**MAJOR PROJECT ASSESSMENT:  
Section 75W Modification  
6 -16 Atchison Street, St Leonards  
(09\_0187 MOD 2)**

Director-General's  
Environmental Assessment Report  
Section 75W of the  
*Environmental Planning and Assessment Act 1979*

February 2014

BASEMENT LEVEL 2

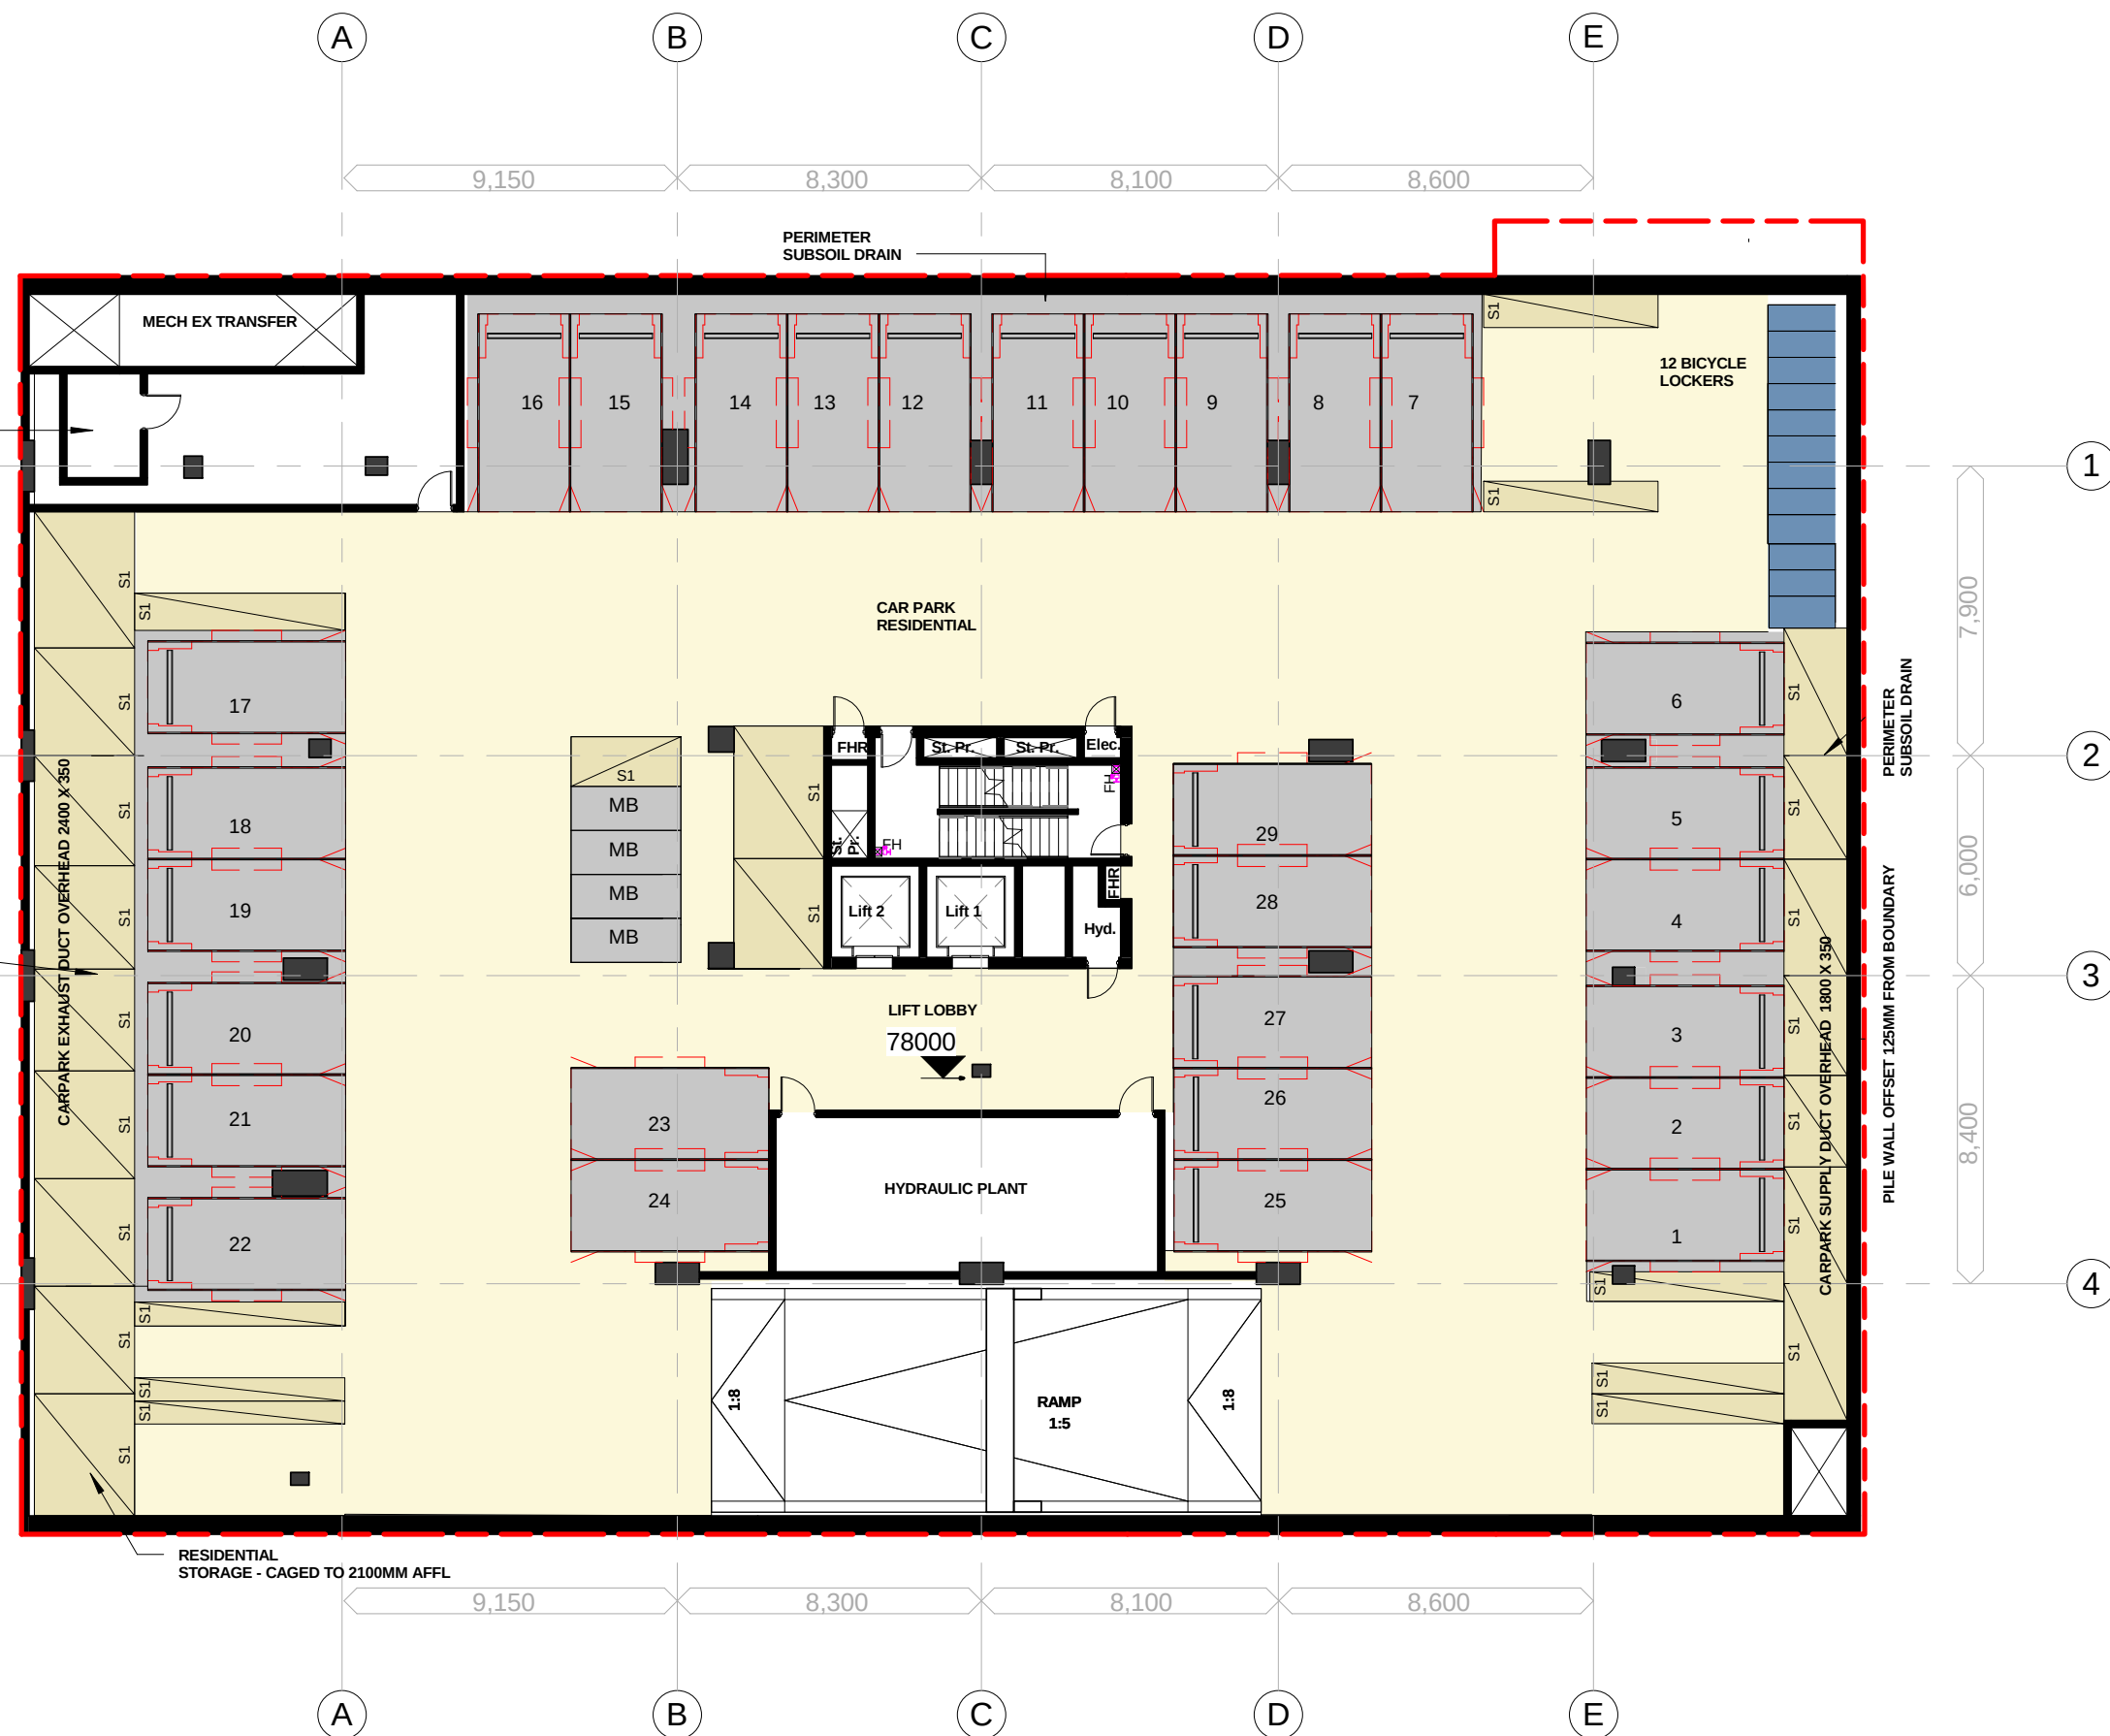
The arrangement is inadequate and Council's contractors will not collect waste from the property. A Section 88B instrument is recommended to alert future owners.

The Council reiterated its previous concerns about the application. Council raised an additional concern that the proposed relocation of the sub-station and siting of the loading dock will limit the through-site pedestrian link, making it uninviting and narrow for members of the public unable to use stairs.

- serviced apartments will be retained on level four to increase the total non-residential GFA to 4365 m<sup>2</sup> (equating to an FSR of 2.5:1 and an increase in the number of serviced apartments from 38 to 64);
- separate entry lobbies and lifts for the residential and serviced apartments have been reinstated as per the Project Approval;
- basement servicing and access will be provided as per the Project Approval. This will be modified slightly by the ramp design recommended by the agency's independent traffic expert (see section 5.2 and the recommended instrument of modification);
- balconies to the western facade of level four were incorrectly omitted from the application as lodged, and their reinstatement will ensure a consistent approach for all levels containing residential units and provide a high level of privacy and amenity for occupants and neighbours; and

SK02 25 NOV. 2013
6-16 ATCHISON ST ST. LEONARDS
RAMP COMPARISON

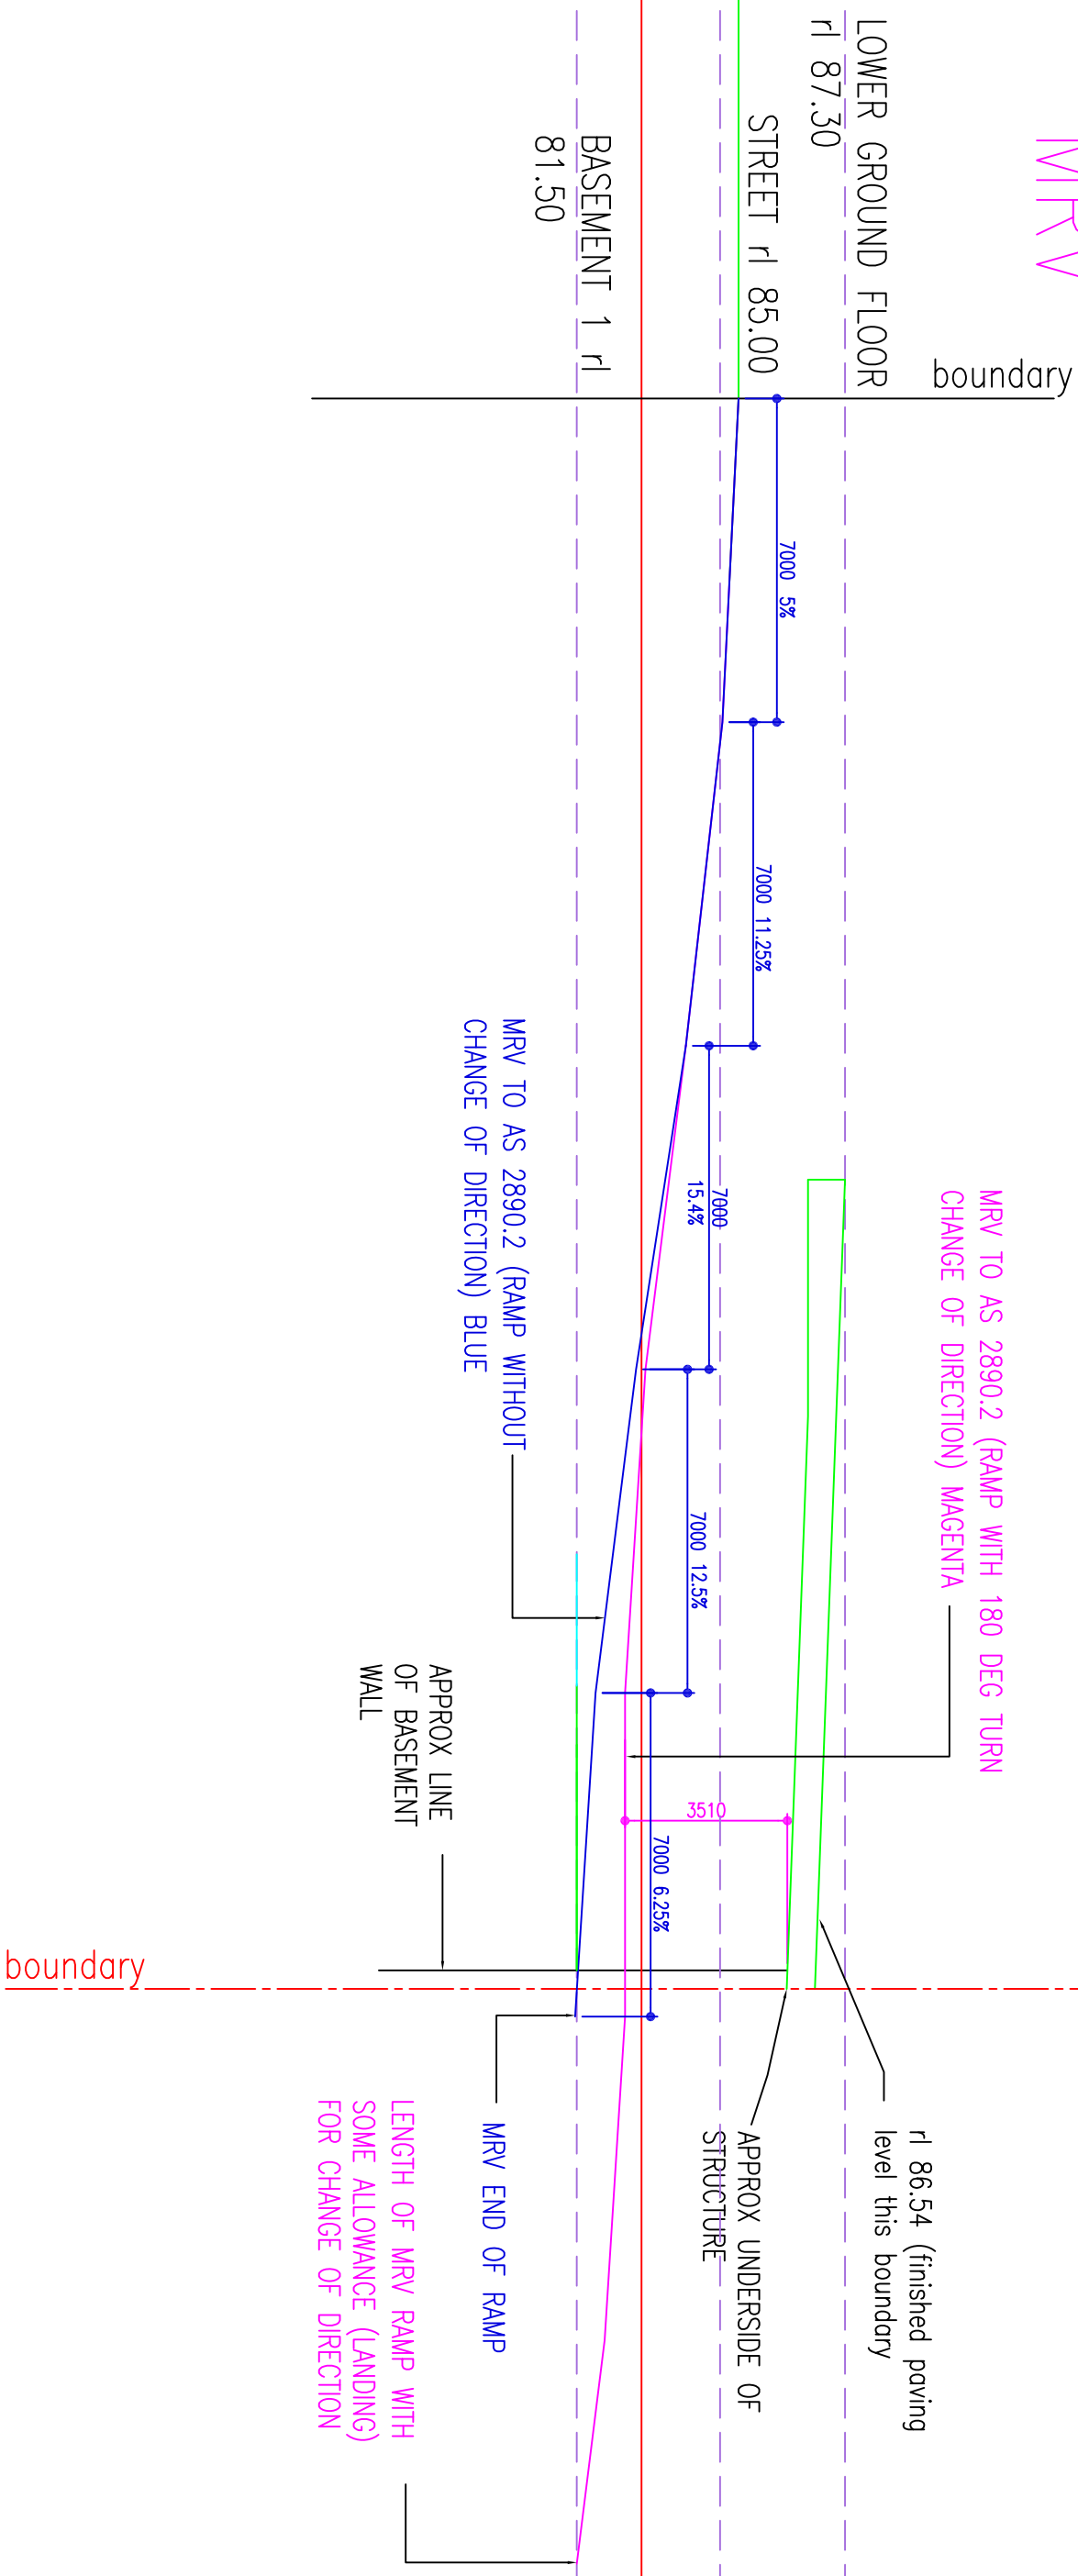
The agency engaged ARUP, an independent traffic expert, to review the proposed basement layout and provide an assessment of the proponent's justification for an at-grade loading dock on Atchison Lane (as proposed in the application as lodged). ARUP concluded that the basement ramp could be redesigned (to accommodate a Council garbage vehicle to a 3.6 m height clearance). This would significantly reduce the length of the ramp and associated loss of ground level public domain compared with the application as lodged, and is similar to the approved scheme.

The response to submissions incorporates the recommendations of the agency's traffic expert who confirmed the design complies with the Australian Standards, and is satisfactory in terms of internal manoeuvrability and ramp design subject to a minor amendment to ensure adequate vertical headroom clearance (at points 1 and 2 in **Figure 5**). This is reflected in the recommended modification instrument. The agency supports the application and recommends the Project Approval be modified in accordance with the traffic expert's recommendations.
